Objection to Planning Application LU/3/11

Rear extension, Garden Store
@ Berry House, Berry Lane, Littlehampton

Proposed garden store - floor plan

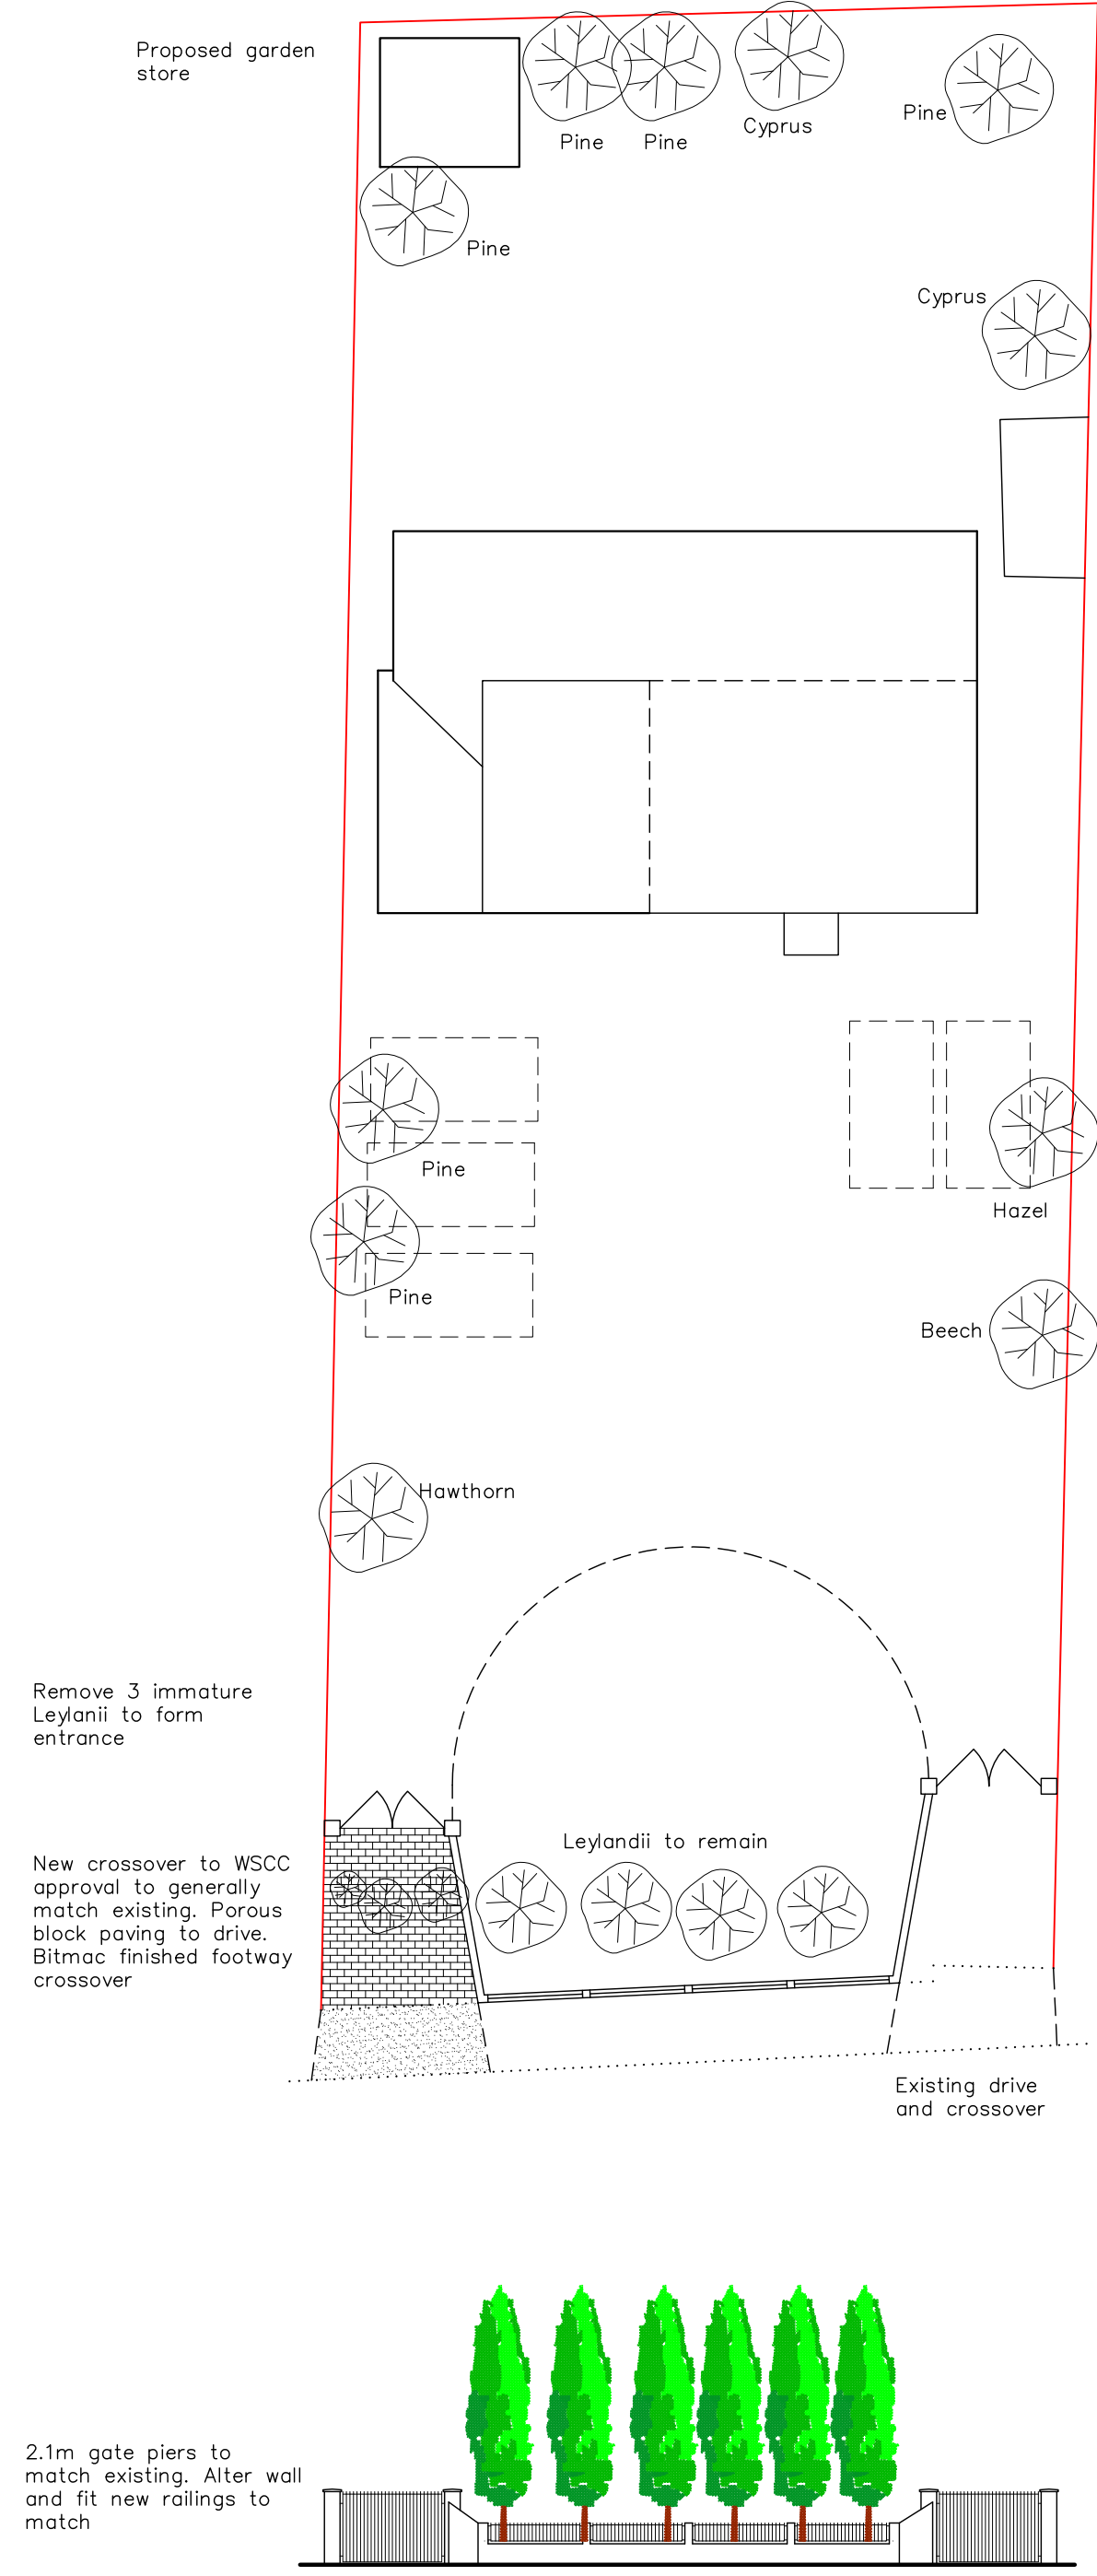
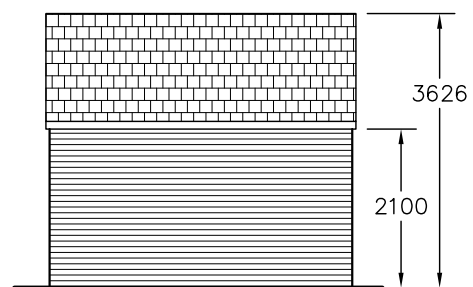
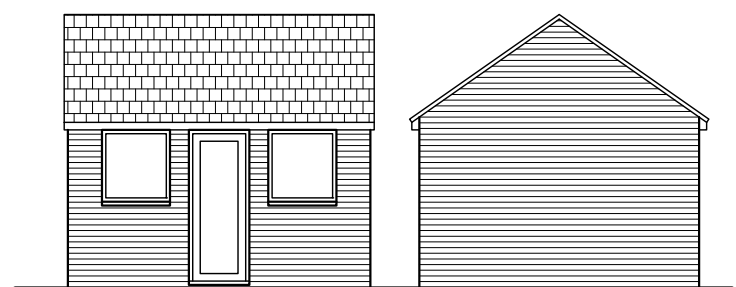
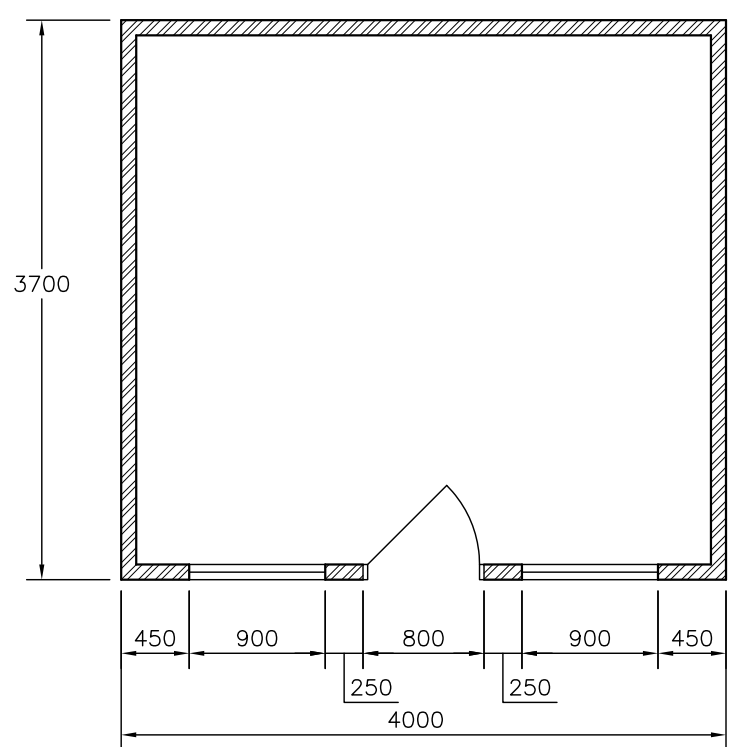
The proposed storage shed is 4 metres by 3.7 metres, nearly 4 metres high. This means that the brickwork and tiled roof will extend 2 metres above the 6 foot high wooden fence and will be totally inappropriate visually to the adjacent residents.

The proposals show no method for the disposal of rainwater.

This is large, tall & too near

the neighbours' fence. It will be intrusive
+ an eye sore.

Berry House. The proposed garden stone which is being built has already almost reached the top of the fence and according to the plans will come much higher - this will further block any sun light coming into our garden. There are already very large fine trees.

The stone is also built so close to the fence that water and debris from the proposed roof will drain down into our garden.
